From: Karl McLaughlin
Sent: 21 November 2017 11:34
To: Planning.Responses
Subject: RE: Planning Consultation on: BR/294/17/PL

**Removal of existing external fire escape & erection of rear single storey extension
(BR/294/17/PL)**

21 Lennox Street Bognor Regis PO21 1NA

Plan

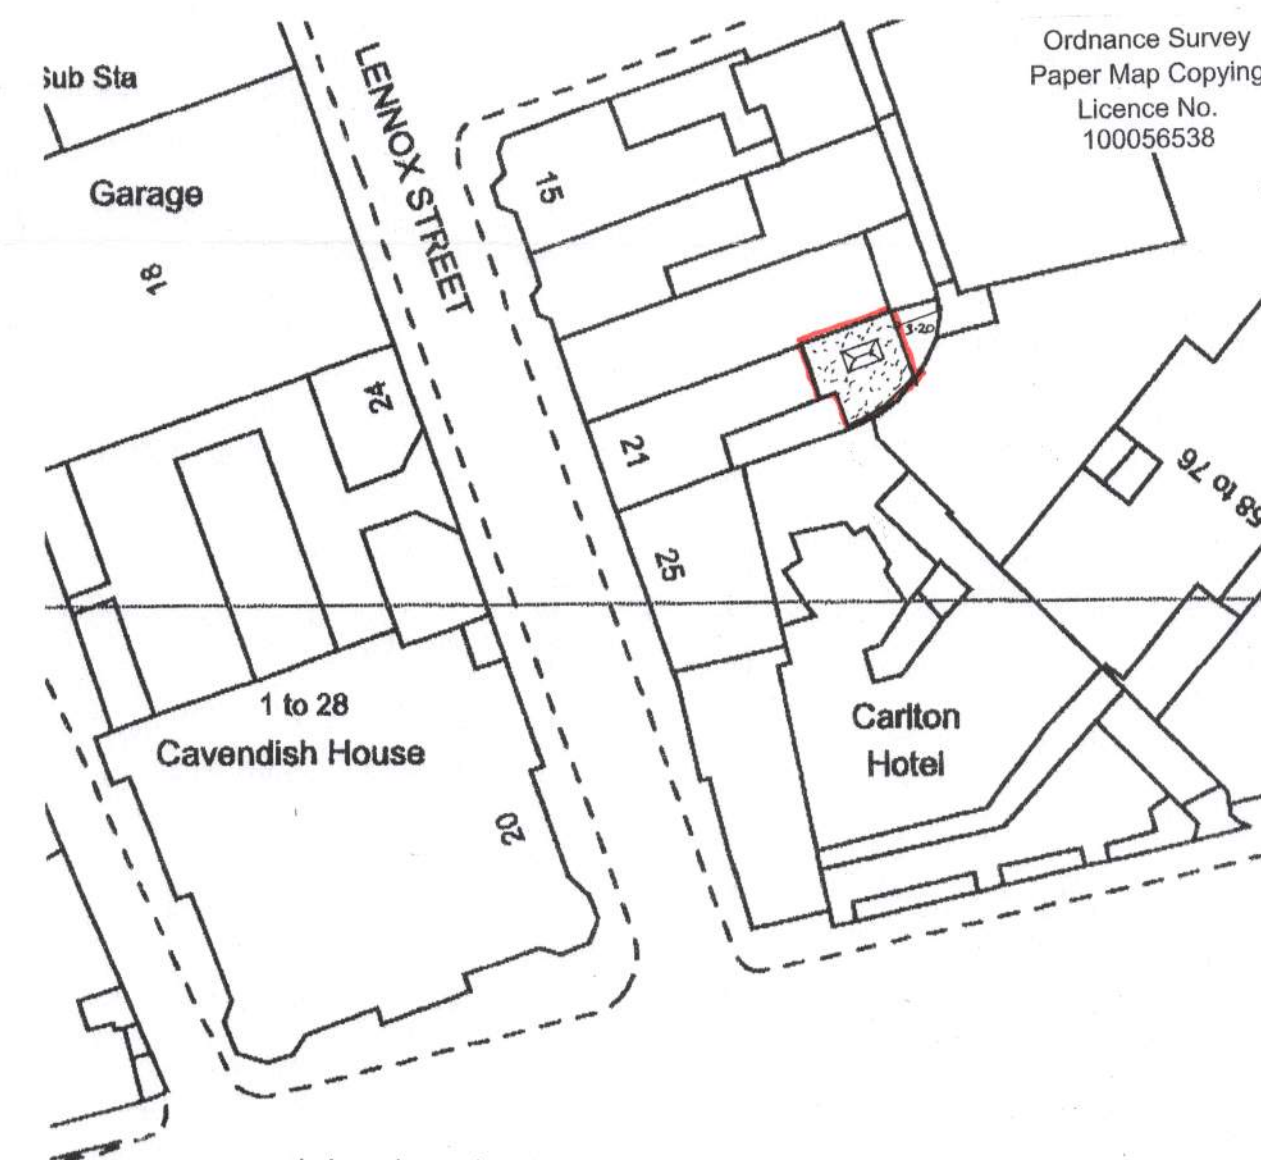
I acknowledge that the proposal is somewhat protected by the seawall, groyne field and shingle beach arrangement however overtopping of the defences must still be considered. The flood risk assessment has given consideration to combatting these issues though the application has not provided indicative floor levels. This is something that the applicant may want to consider. We would expect to see finished floor levels set above the 1 in 200 undefended level + allowance for climate change i.e. 4.94m AOD.

Additionally, we would advise that if approved, this application have the following condition is attached.
Suitable flood risk measures be provided and maintained to all external doors in perpetuity to the satisfaction of the LPA. This could be achieved as set out in the application's flood risk assessment, i.e. "Provide 600mm high plastic OR aluminium flood boards in watertight channels fixed to door frames in event of possible flood warning." Alternatively, this condition could also be met by installing suitable flood resistant doors. Provision of suitable flood risk measure may lead to the ability to relax the FFL requirement above.
